From: Simon Davis
Sent: 11 March 2019 11:48
To: [REDACTED]
Subject: RE: BR/326/18/PL - The Royal Hotel, The Esplanade, Bognor Regis

From: [REDACTED]
Sent: 25 January 2019 16:52
To: Simon Davis <Simon.Davis@arun.gov.uk>
Subject: BR/326/18/PL - The Royal Hotel, The Esplanade, Bognor Regis

CLIENT	Metamorph Management LLP
PROJECT	The Royal Hotel Apartments
DATE	December 2018
DRAWING TITLE	Proposed South Elevation

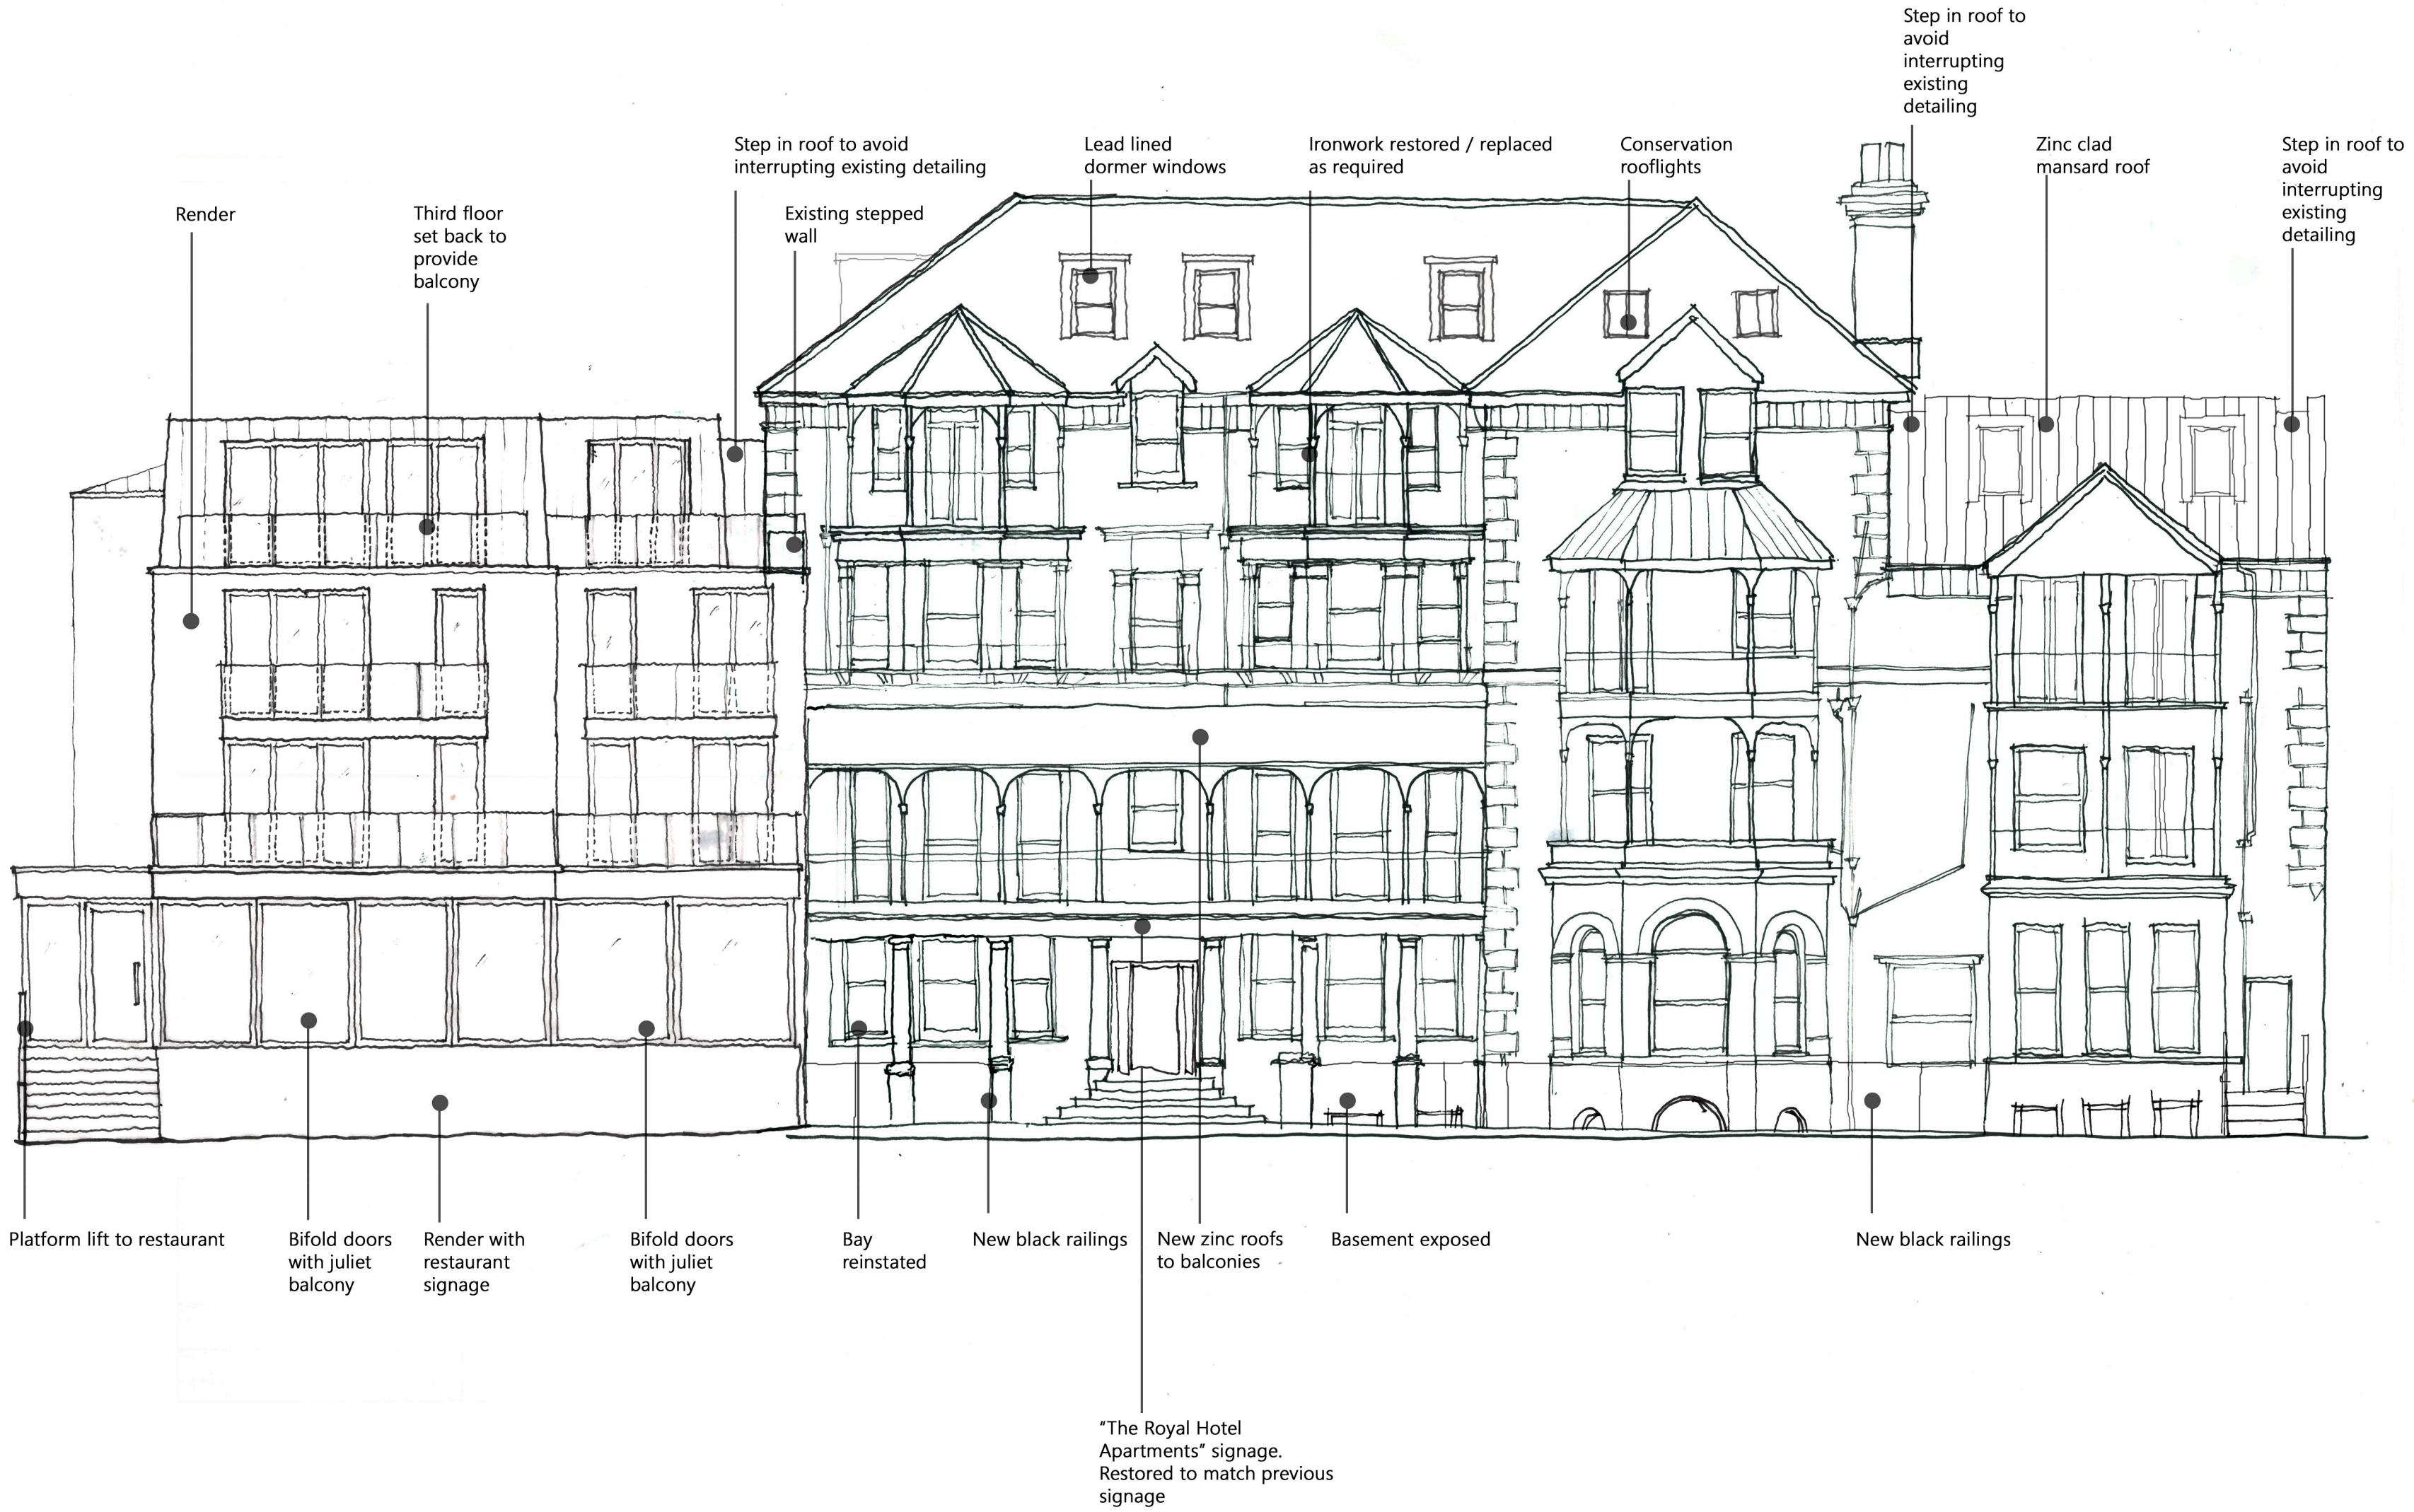
Separately, please see two annotated plans attached. On the roof plan (block plan), it looks like there is a dormer on the eastern flank of the main roof and this is not shown on the N or S elevations. It may be that the missing dormer is actually a velux or the position of the chimney though (as I don't have the fourth floor plan, I haven't been able to check). Also there is a conservation rooflight shown on the N elevation of the main roof but not shown on the roof plan.

Yes, I think that is a "fair cop", thanks for drawing to my attention, I attach the 4th floor plan but this does not very clearly show the dormer either, so I have requested revised north and south elevations, roof plan and 4th floor plan from the architects. I will forward these ASAP.
